Application No. H19/0211/03/A1

Revised siting of proposed bungalow

**Planning Application Ref. H19/0211/03 – Bungalow and detached garage
Plot 2, South Eau Bank, Gedney Hill.**

Drawing No.
AD/1

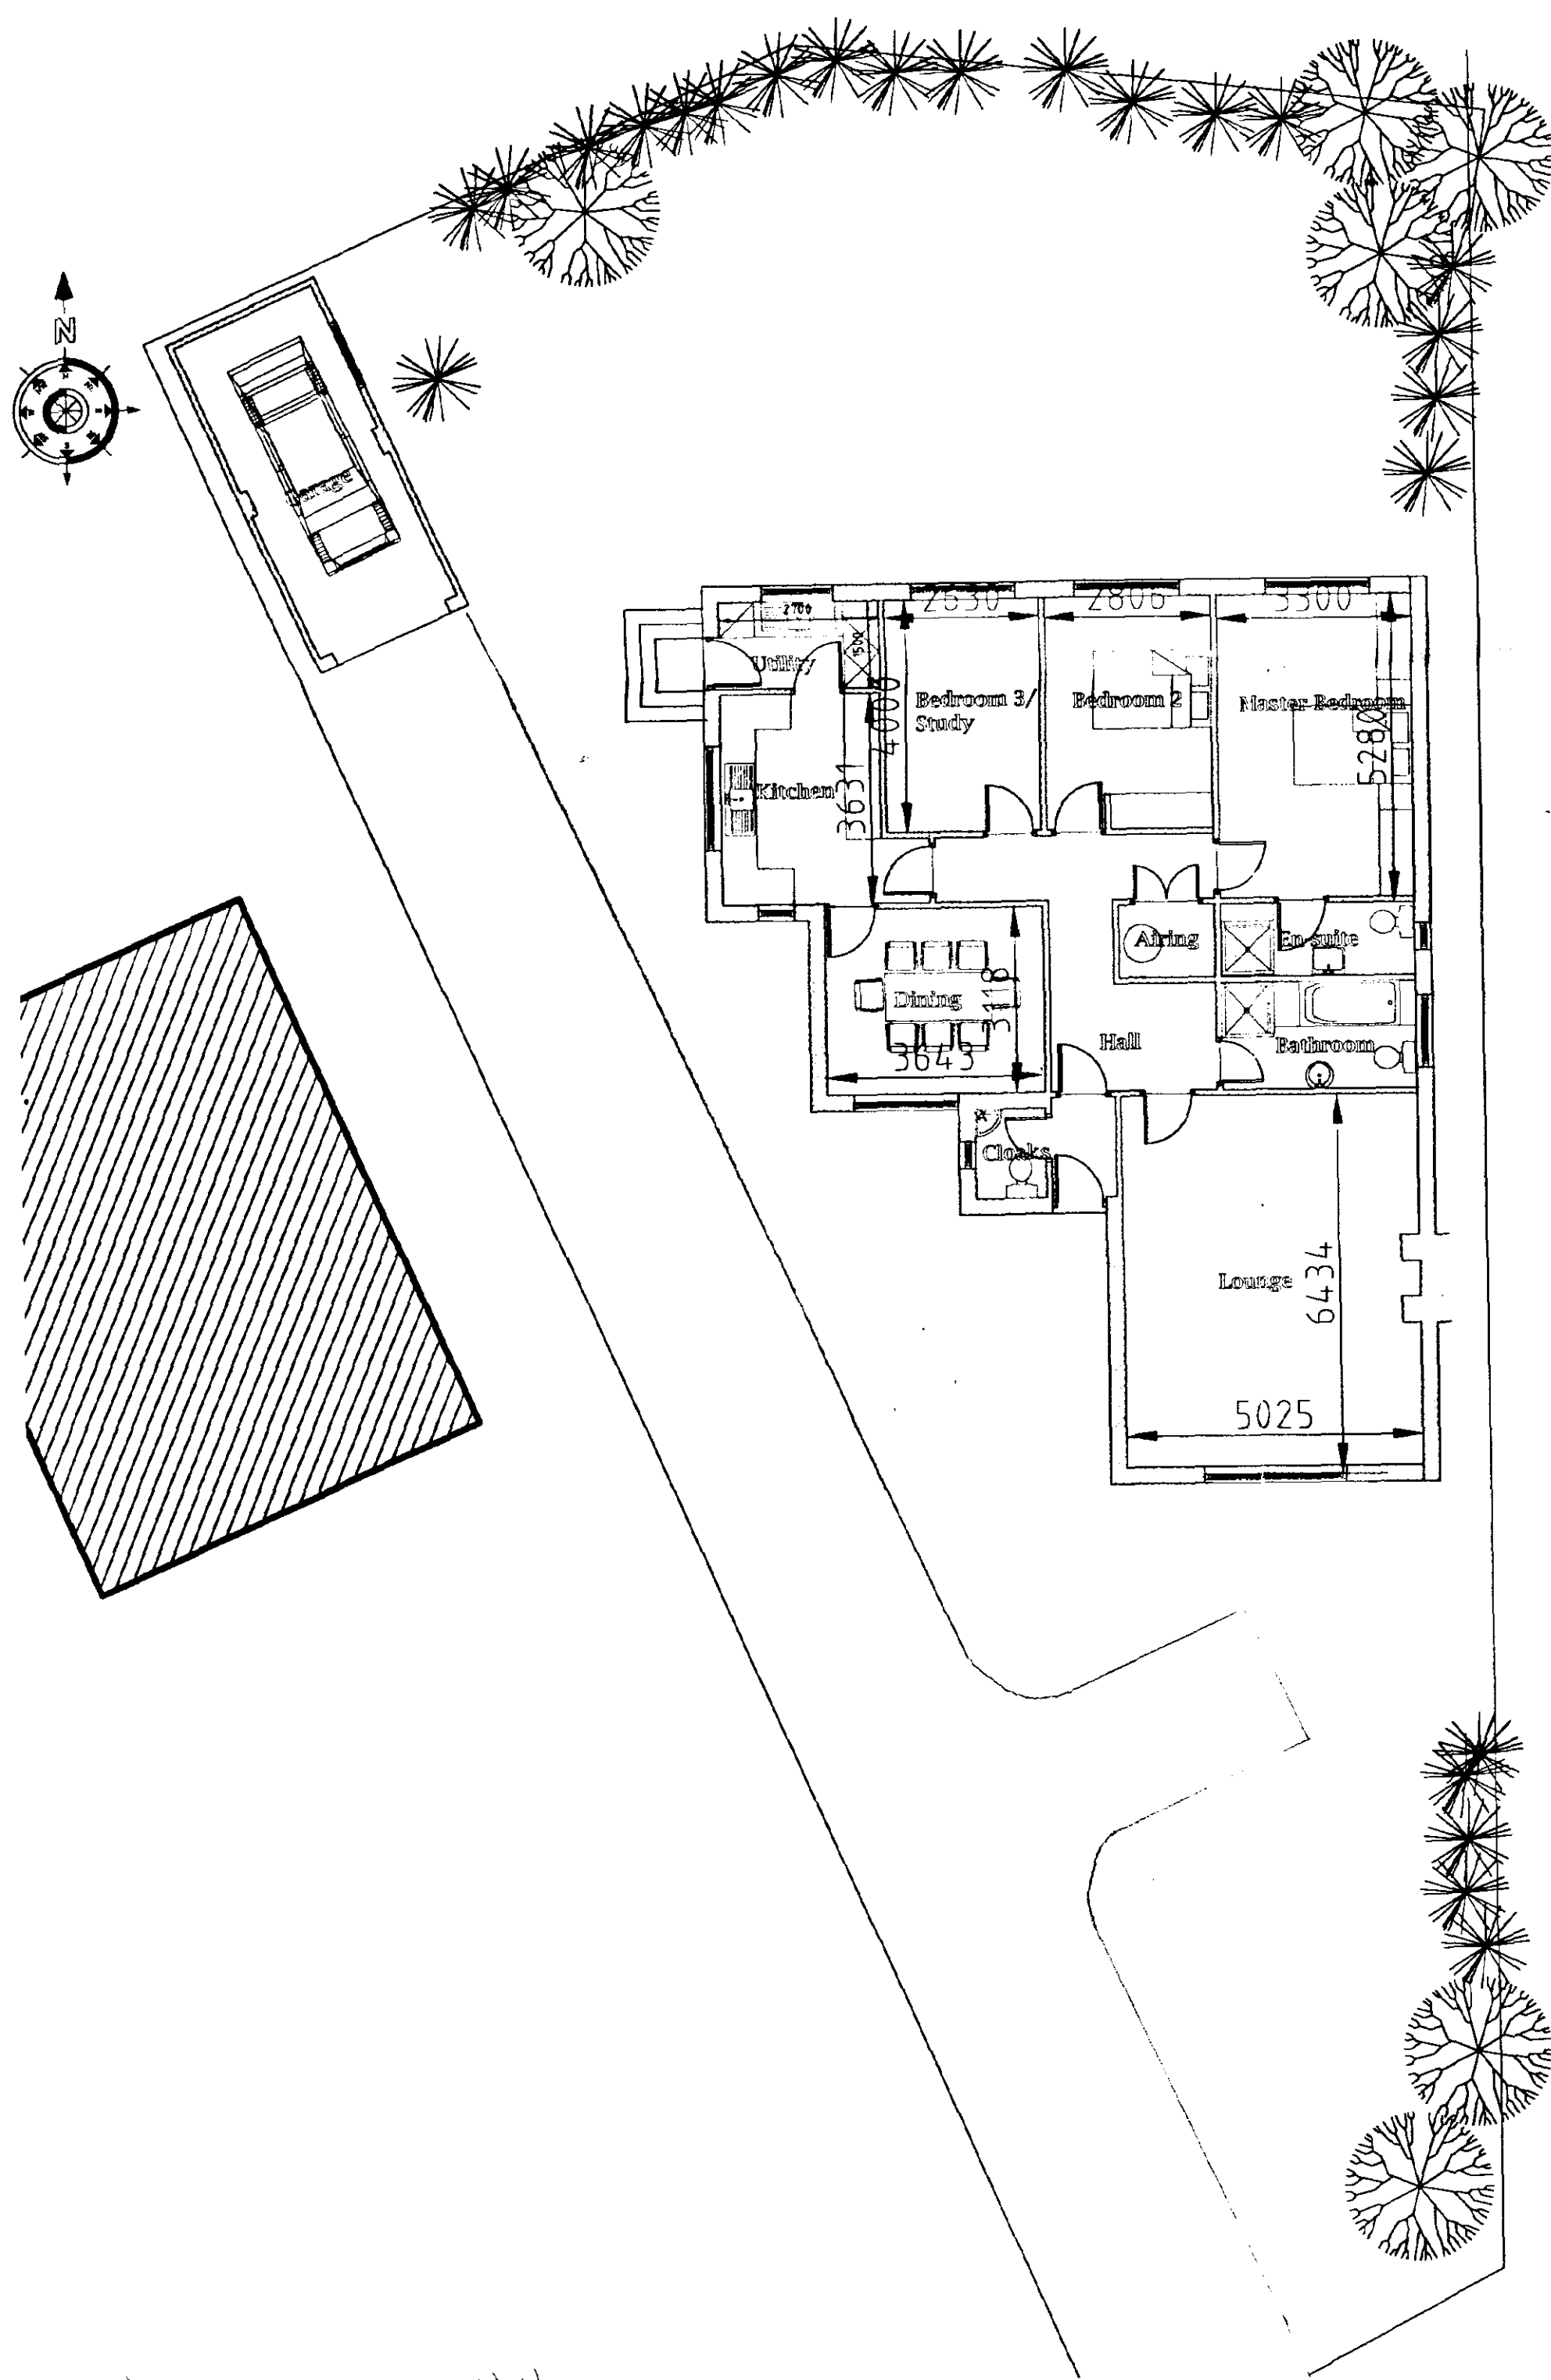
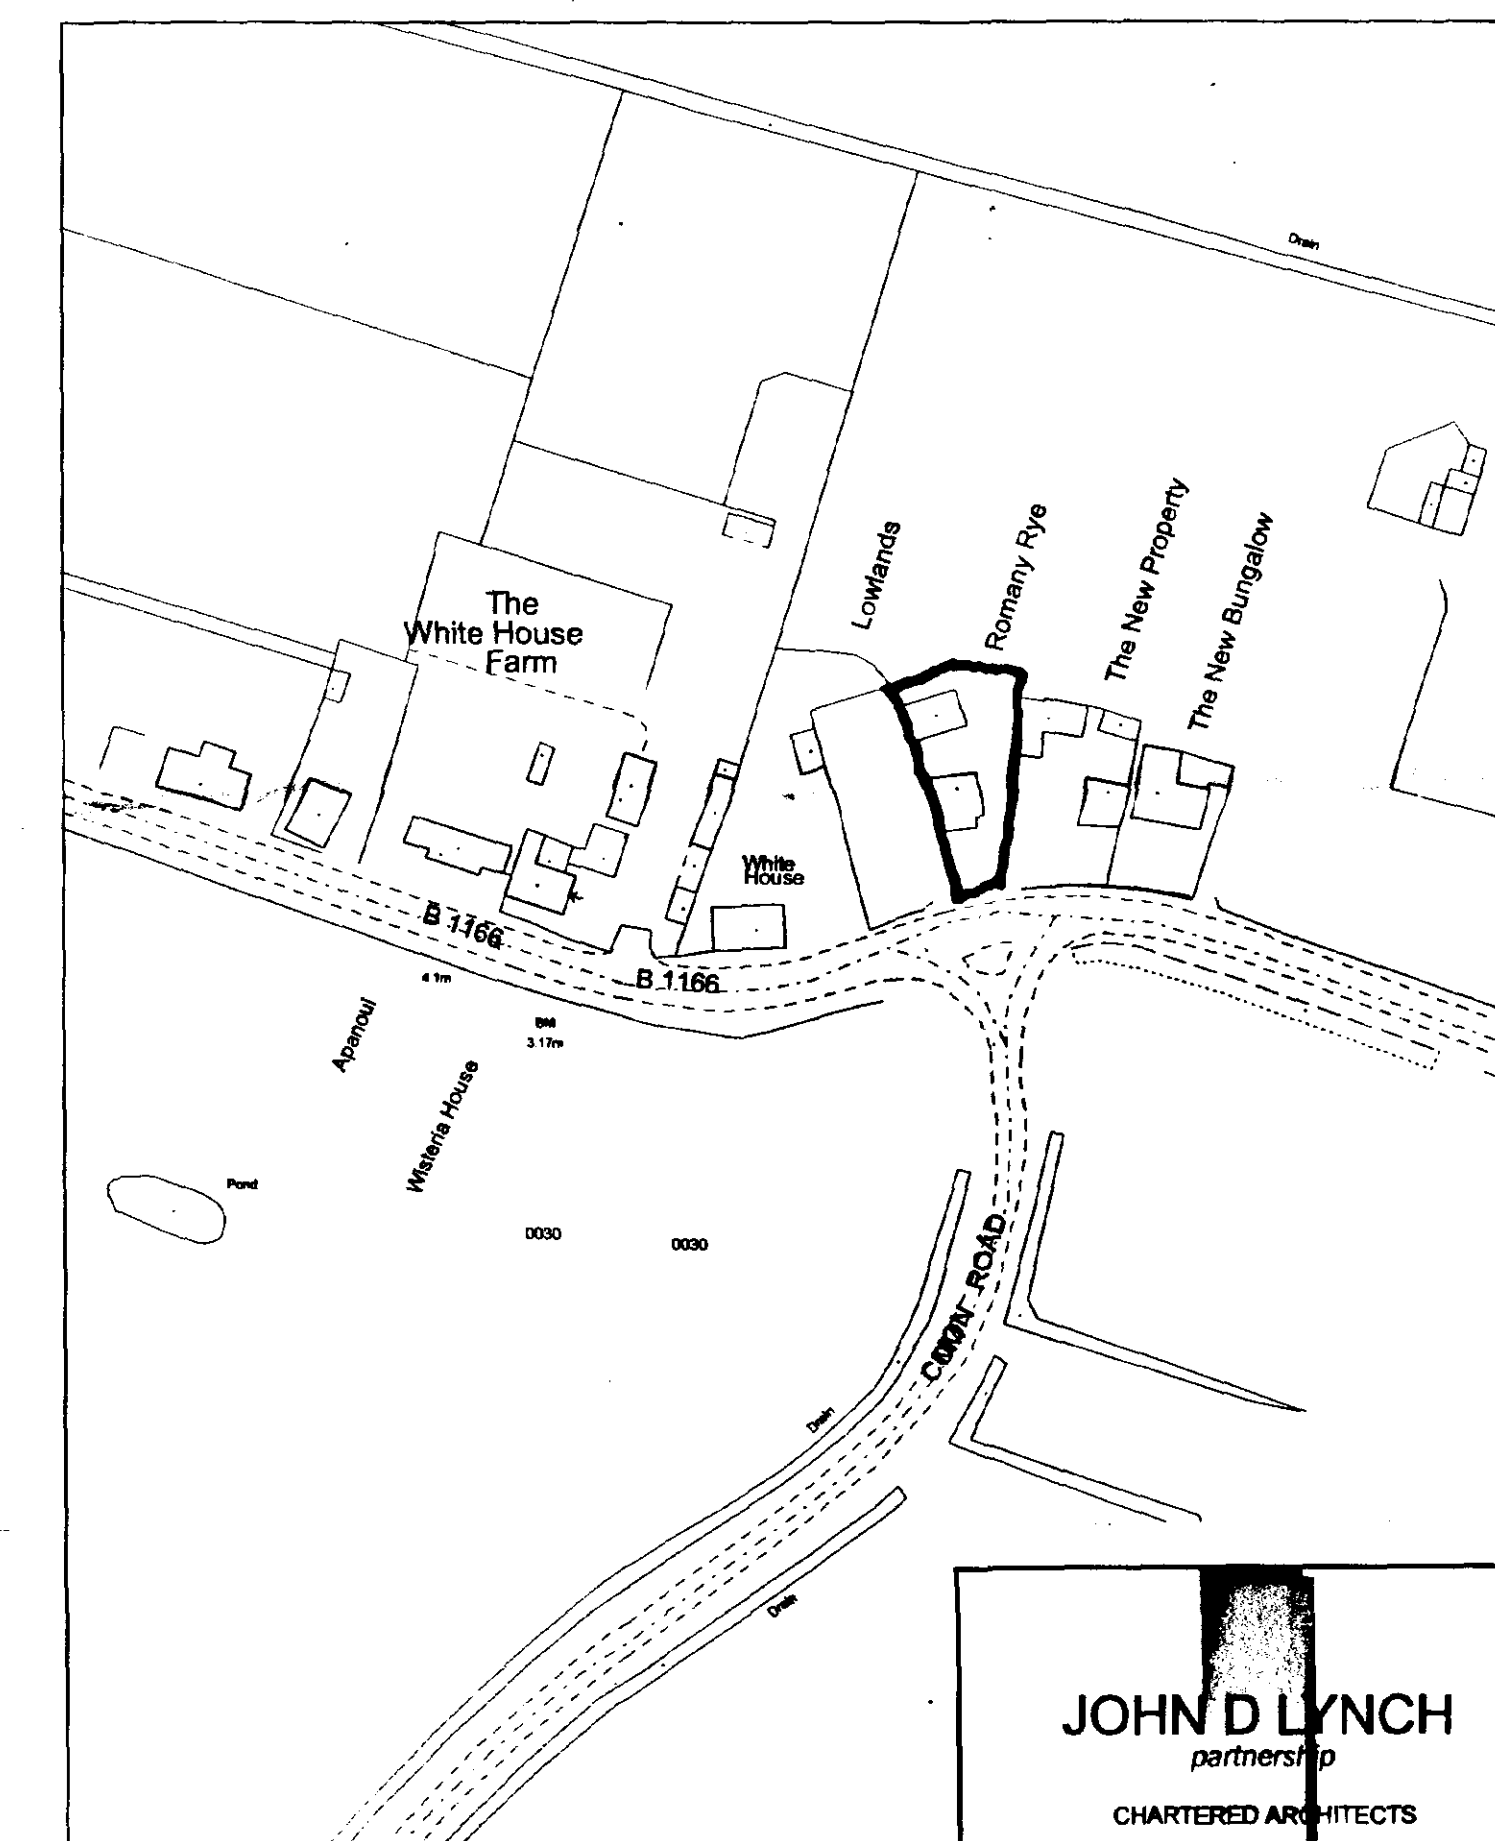
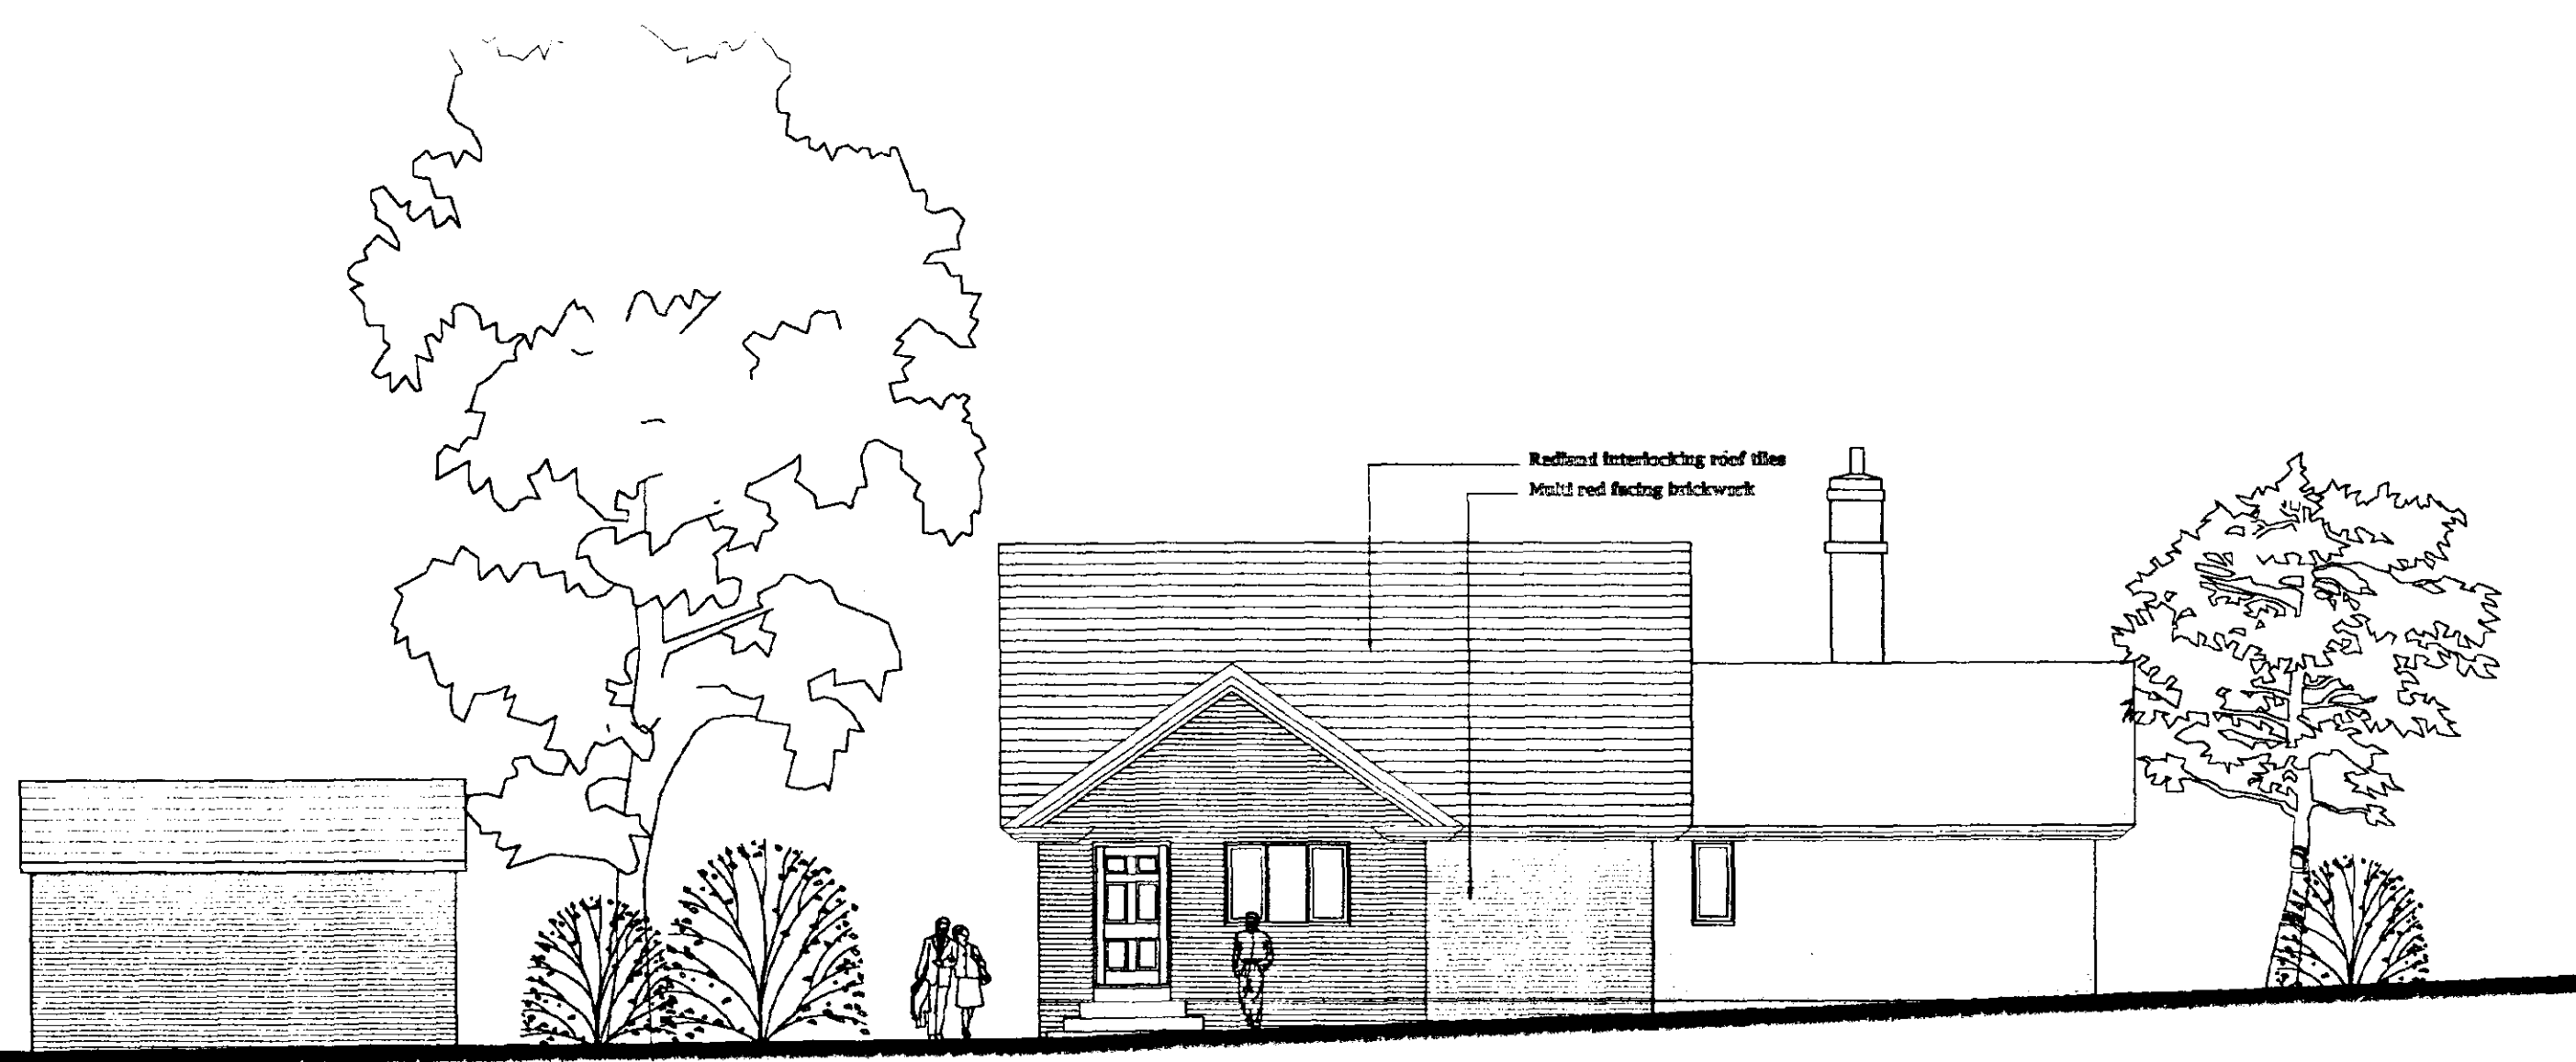
I have discussed the matters which you have raised with my clients and they are agreeable to the changes which you have recommended. We have therefore positioned the bungalow 500mm further from the eastern boundary and moved it towards the rear. In taking the turning bay to the front of the plot, we have moved the bungalow further to the rear than your letter might suggest. On balance we feel that this is a worthwhile improvement and would hope that this enables you to release a permission.
